Re - Hobbs Court Farm, Bilsham Road, Yapton, Arundel, West Sussex. BN18 0JY - UPDATED DRAWINGS

From: Simon Davis
Sent: 18 November 2013 16:55
To: 'Paul Clarke'
Cc: 'Tom'; [REDACTED] Martyn White
Subject: RE: Hobbs Court Bilsham Road, Yapton, Arundel. Y/59/13/ and Y/60/13/L

Y/59/13/

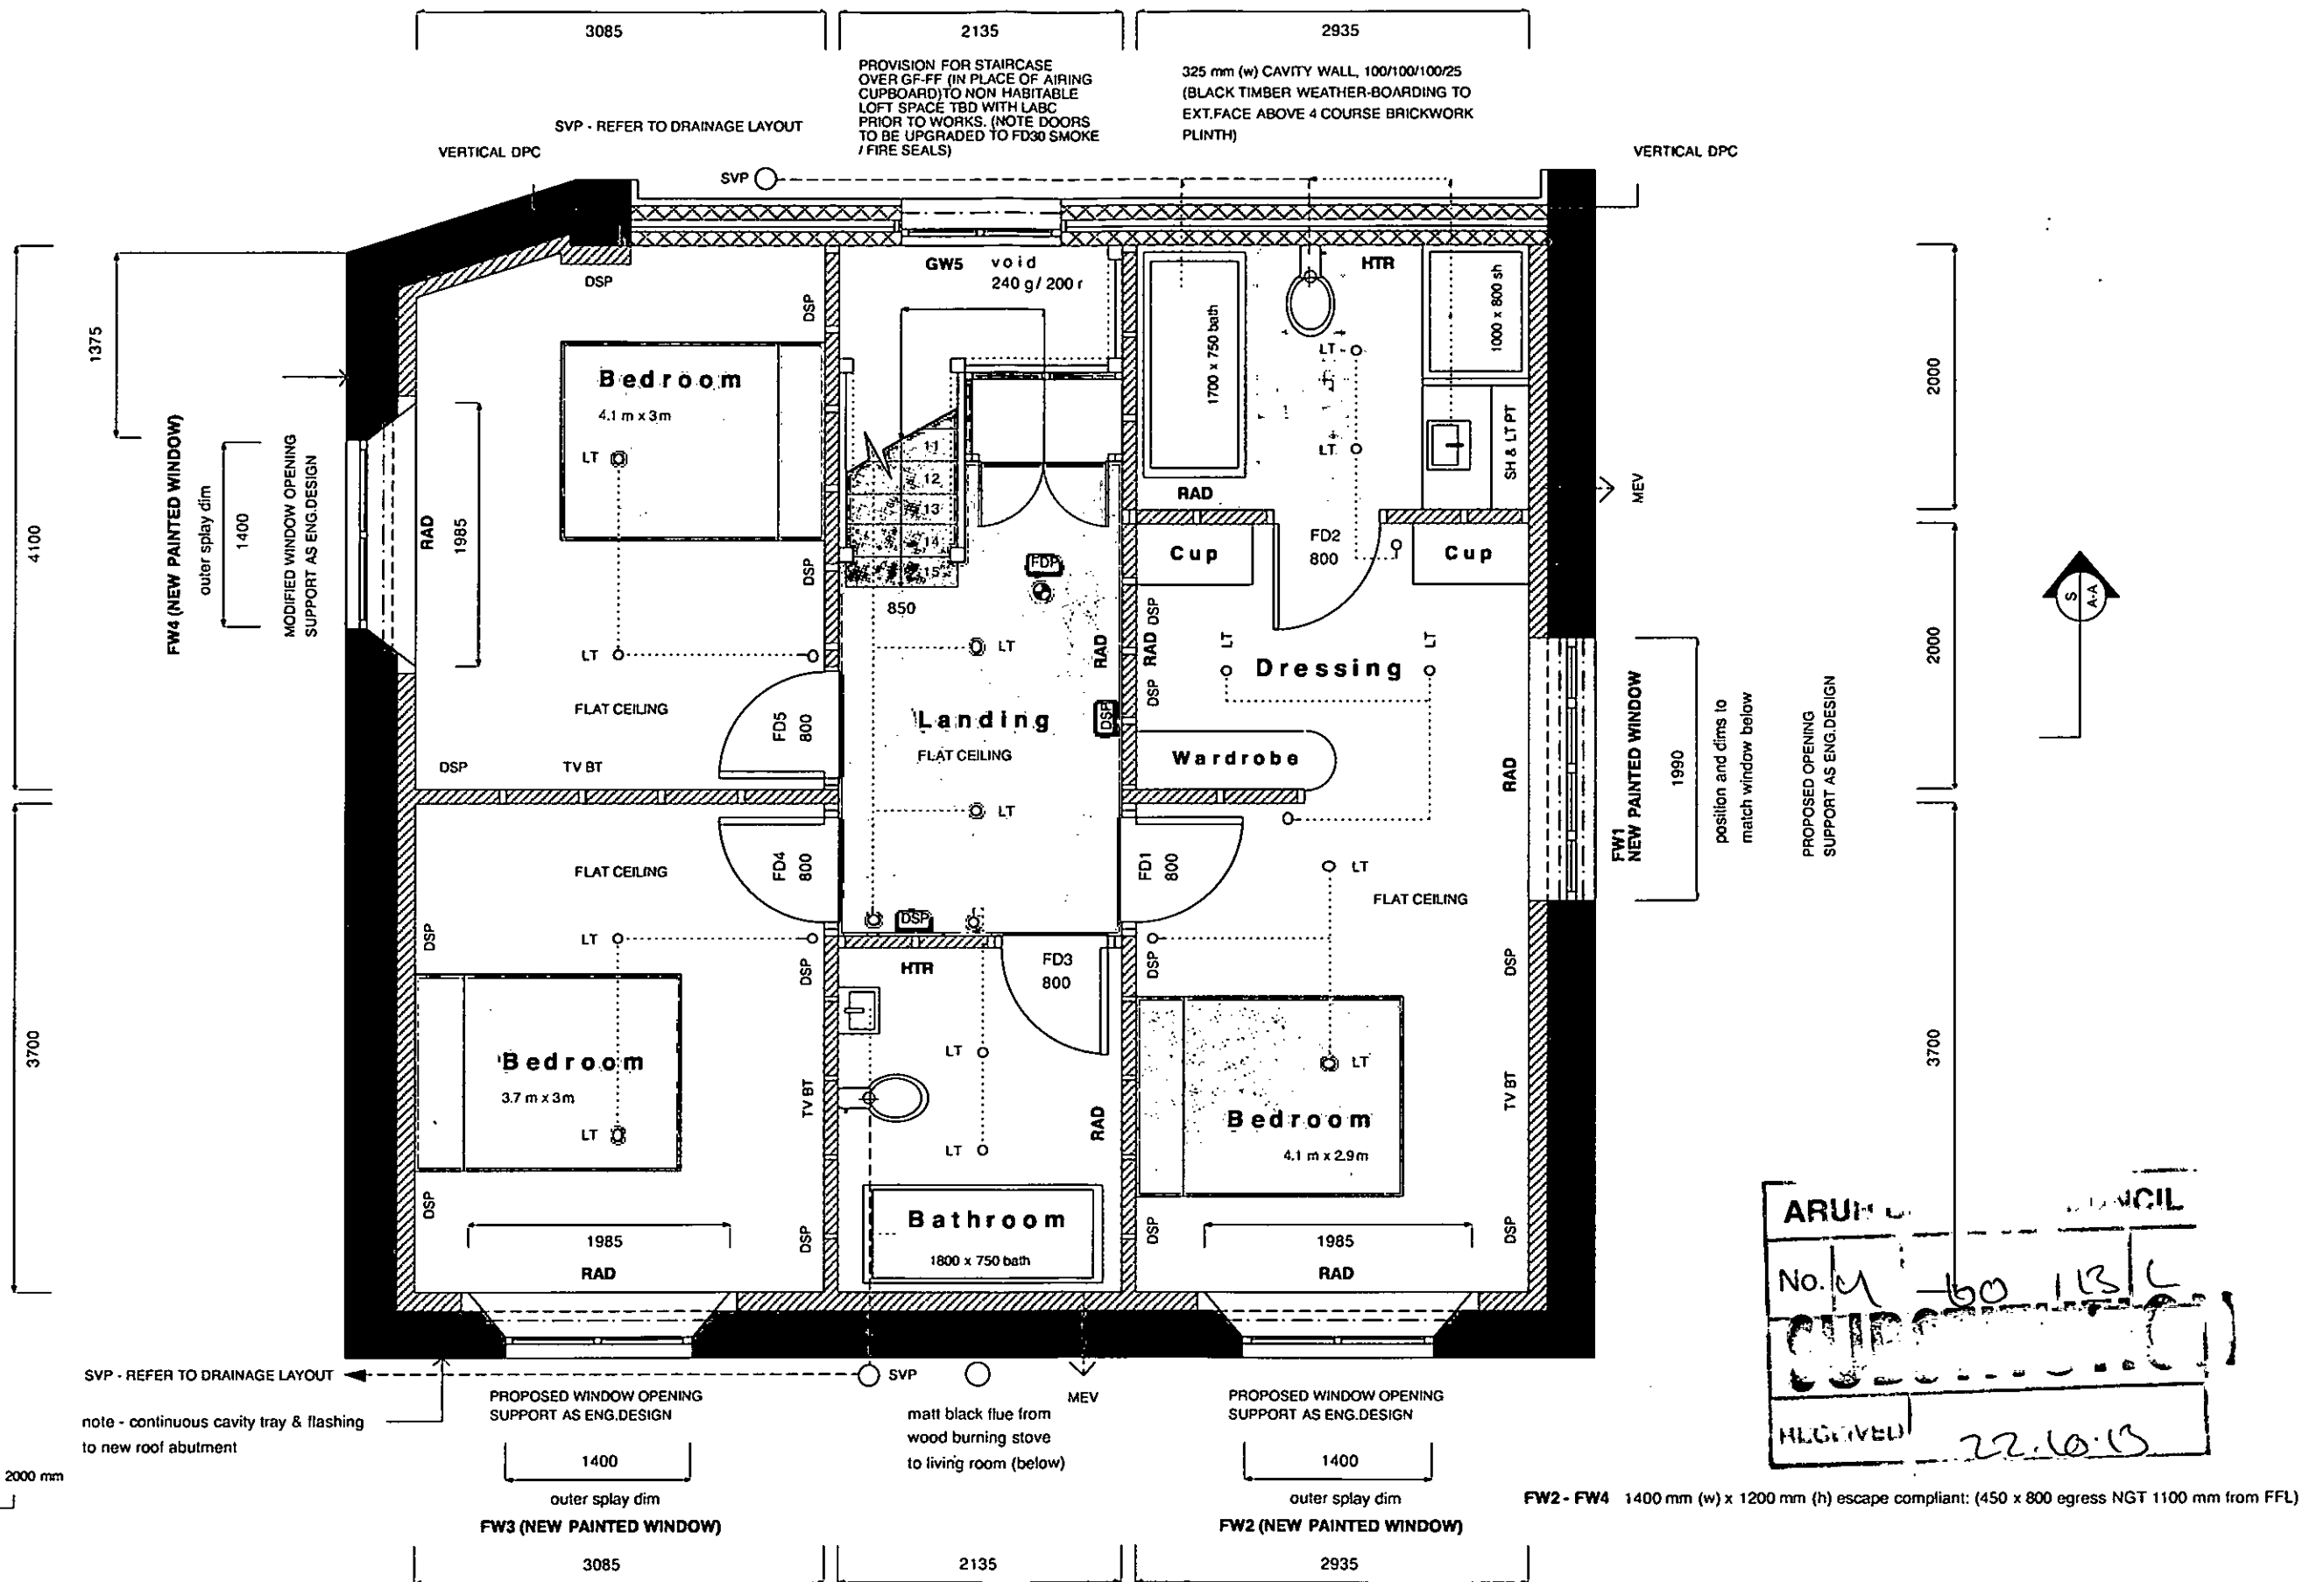
I have now looked through the plans and compared them to the existing set. I do not feel that there is a need to re-consult neighbours and I am also prepared to accept 004B and 004C without any re-consultation (although I would ask that this new bathroom window be shown on the plans as obscure glazed).

I do have a couple of queries however. Firstly, you mention a couple of changes to Cottars but yet there are no plans attached to show these changes. I will need these new plans but in respect of these changes, I feel we can accept them without further consultation. Secondly, Martyn White and I have both tried to find the "GW8 Glazing bars added so similar to adjacent window GW1" change but cannot. Can you ensure GW8 is clearly labelled on the plans.

Dove Cott. 003A, 004B, 007A, 008C.
GD8 full height side light added.
GD7 small square window added at head height to gain extra light in kitchen.
GD9 Glazing bars added so similar to adjacent doors on Cottars
GD10 small square window added at head height to gain extra light in kitchen.
GD6 glazing bars added.
GD1 small square window added at head height to gain extra light in hall.
FW5 moved down and across to centre on stair landing.
GW5 added to give light into hall.
GW8 (South elevation to study) Glazing bars added so similar to adjacent window GW2
FW6 Small window into the first floor en suite with obscure glass.
